# Southampton to London Pipeline Project

Responses to ExA's Further Written Questions -  
Turf Hill (TH)

Application Document: 8.43

Planning Inspectorate Reference Number: EN070005

Drawing Status	For Issue
Scale	1:6,210 @ A3 DO NOT SCALE
Jacobs No.	B 23 25300
Project Wise No.	B2325300-JAC-000-ENV-DRG-001499
Drawing number	Figure A7.1.148 Sheet 4 of 4
Rev	0

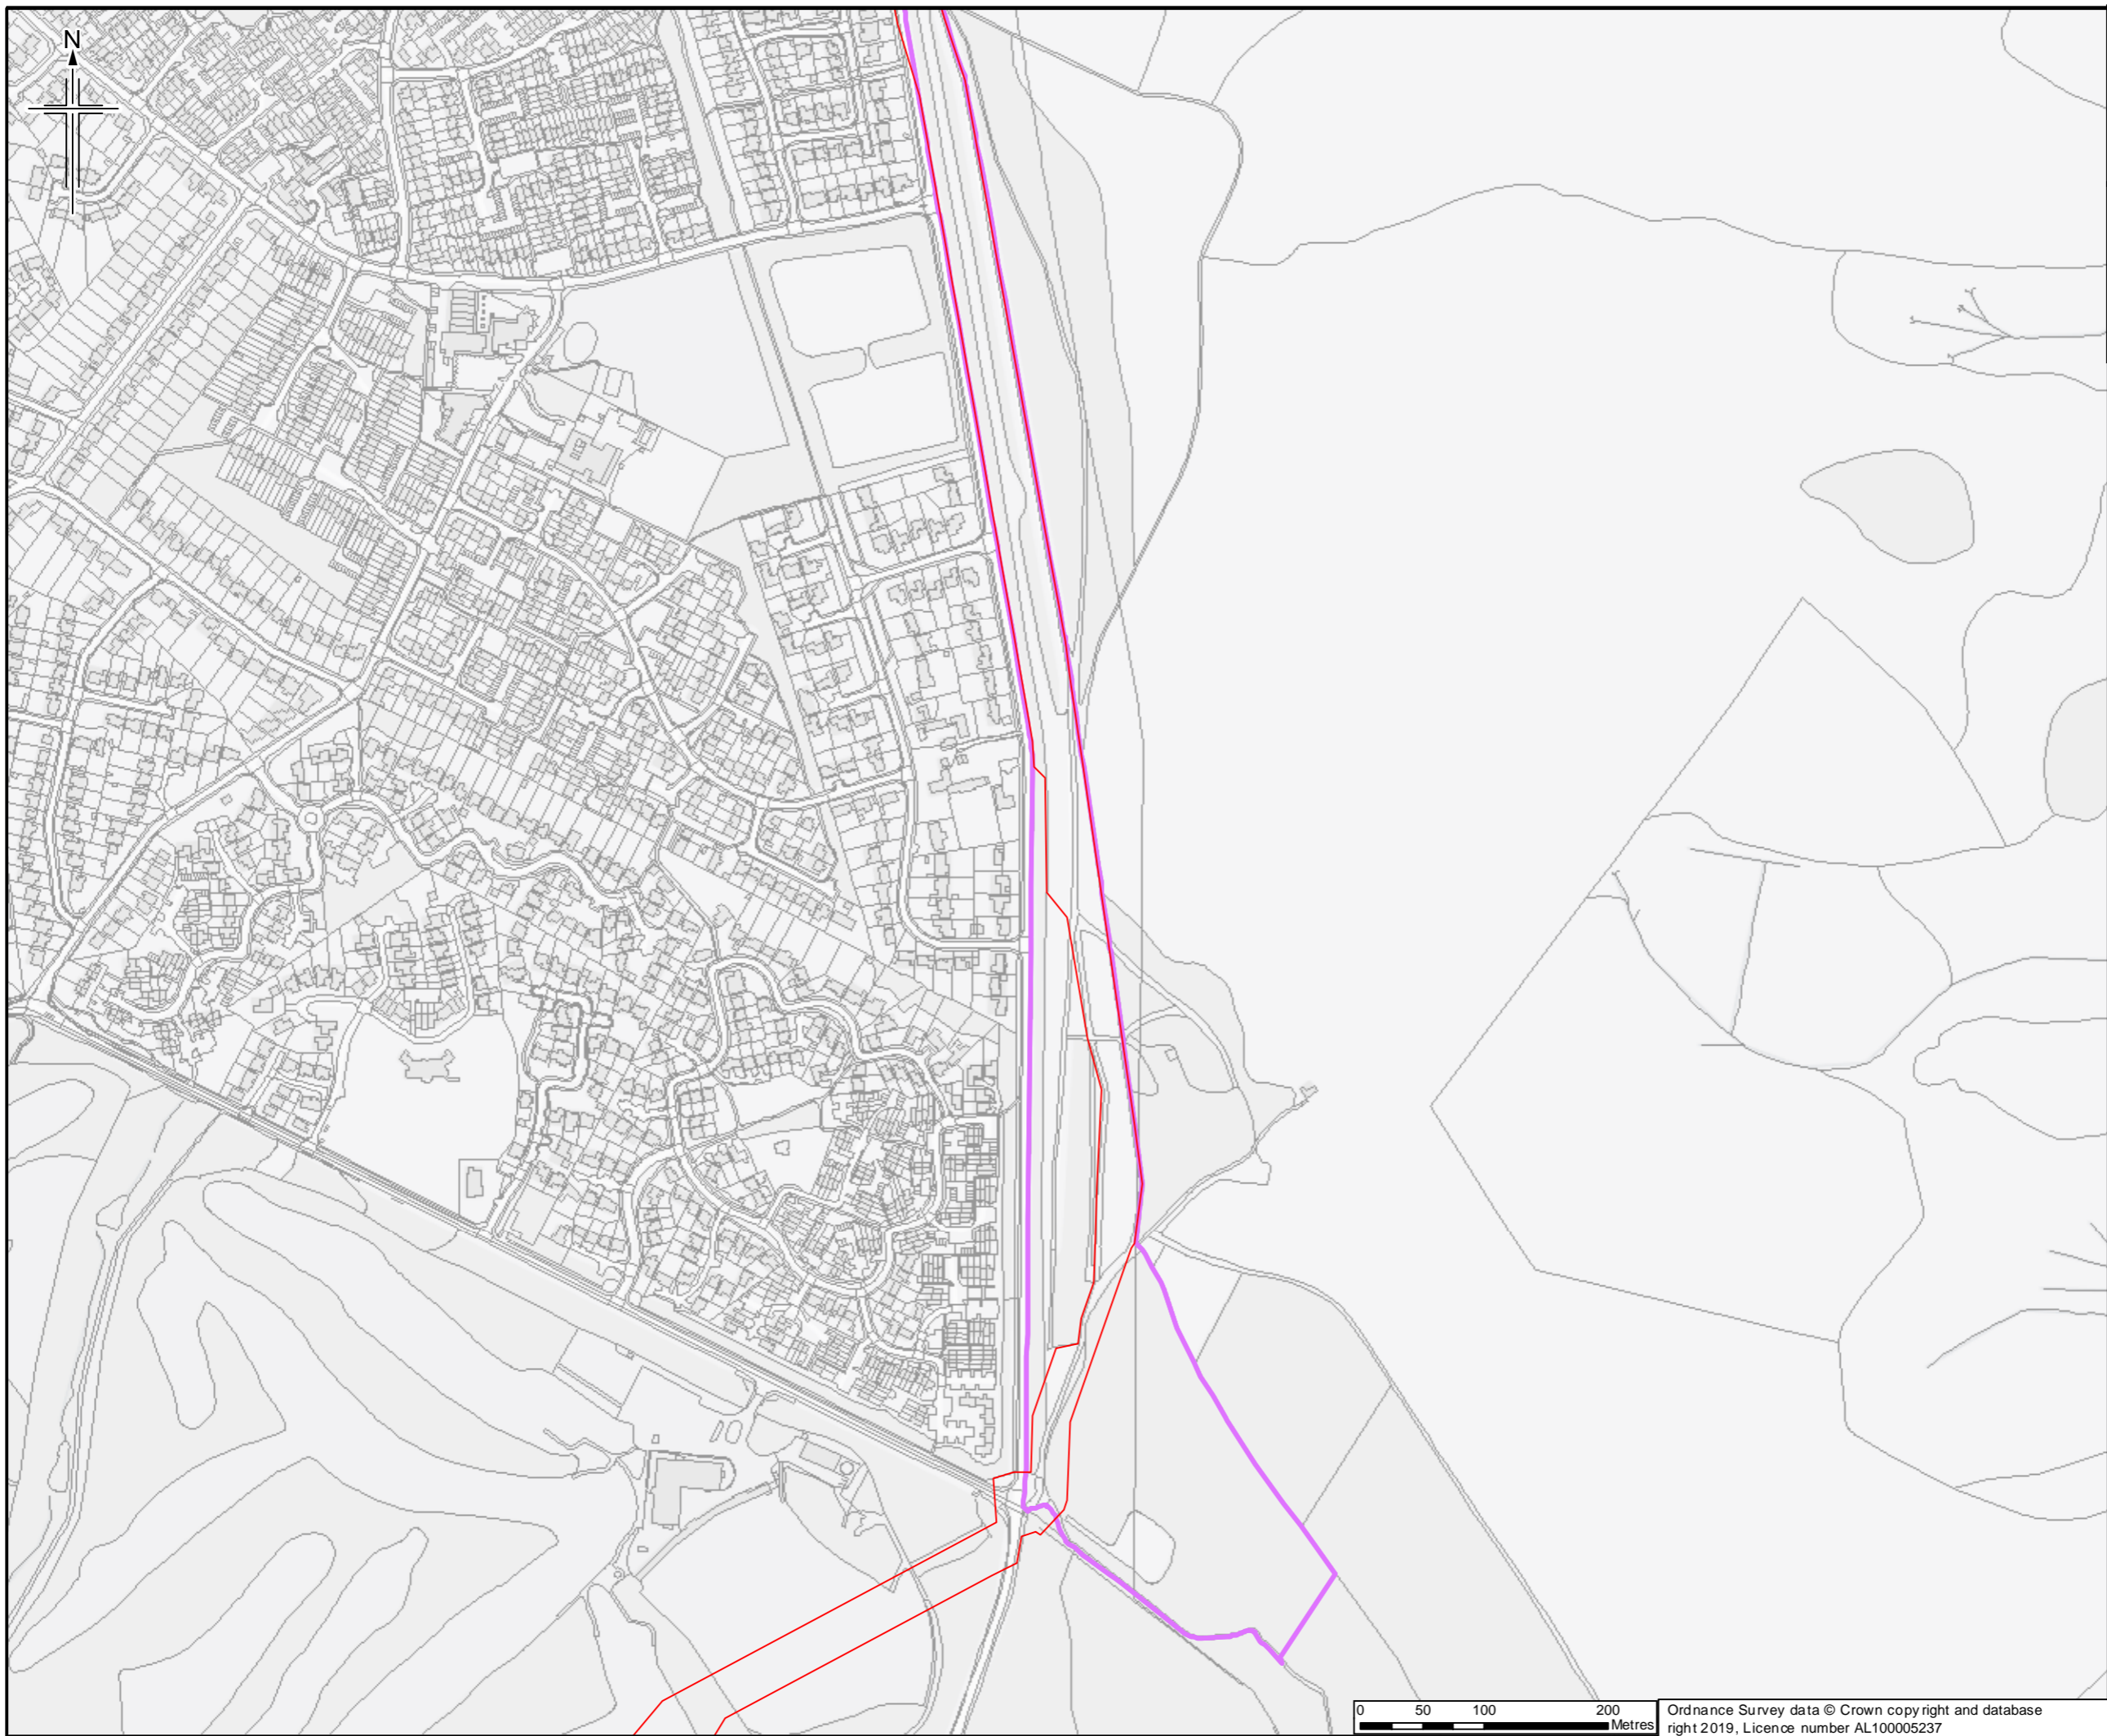
ExQ2	Question:	Applicant response to Question:
	<p>heathland, comment on the specific characteristics including the ecological value of the proposed pipeline alignment (F1a+) and the previously considered option (F1c).</p>	<p>Turf Hill are shown in Figure A7.1.148 Sheet 4 of 4 and the presence of related Annex I habitats are detailed in Figure A7.1.149 Sheet 4 of 4.</p> <p>1.4 The F1a+ route option comprises Scots pine woodland in its entirety with significant amounts of the invasive species <i>Gaultheria</i>. In addition, there is a well-worn public path which accounts for a significant percentage of the F1a+ Order Limits. The F1c option is far more diverse, comprising acid dry dwarf shrub heath and wet dwarf shrub heath which are Annex I habitats (listed within the Habitats Directive 1992 (Council Directive 92/43/EEC on the conservation of natural habitats and of wild fauna and flora)), with linear strips of scrub dominated by common gorse along bare ground used as access tracks. When the habitats of the two route options are compared in terms of ecological value, the F1a route option is far lower.</p> <p>1.5 As a component of the Thames Basin Heaths SPA, Turf Hill is also designated for the bird species nightjar, woodlark and Dartford warbler. These species are ground nesting heathland specialists which is reflected in their breeding location records shown in Figures C7, Figure C8 and Figure C9 in the Habitats Regulations Assessment Report (<b>Application Documents <a href="#">APP-130</a> and <a href="#">APP-131</a></b>). These figures show that while breeding has been recorded in or near the heathland habitats of the F1c option, they have not been recorded in the coniferous woodland habitat of option F1a+.</p> <p>1.6 In conclusion, the habitats within the Order Limits of the F1c option comprise Annex I habitats that are internationally important and support breeding qualifying bird species, whereas the conifer woodland within the Order Limits of the F1a+ route option, although located within the international designation, is not a qualifying feature of the SAC, does not directly support breeding habitat of the qualifying bird species of the SPA and is of much lower ecological value than the Annex I heathland habitats.</p>
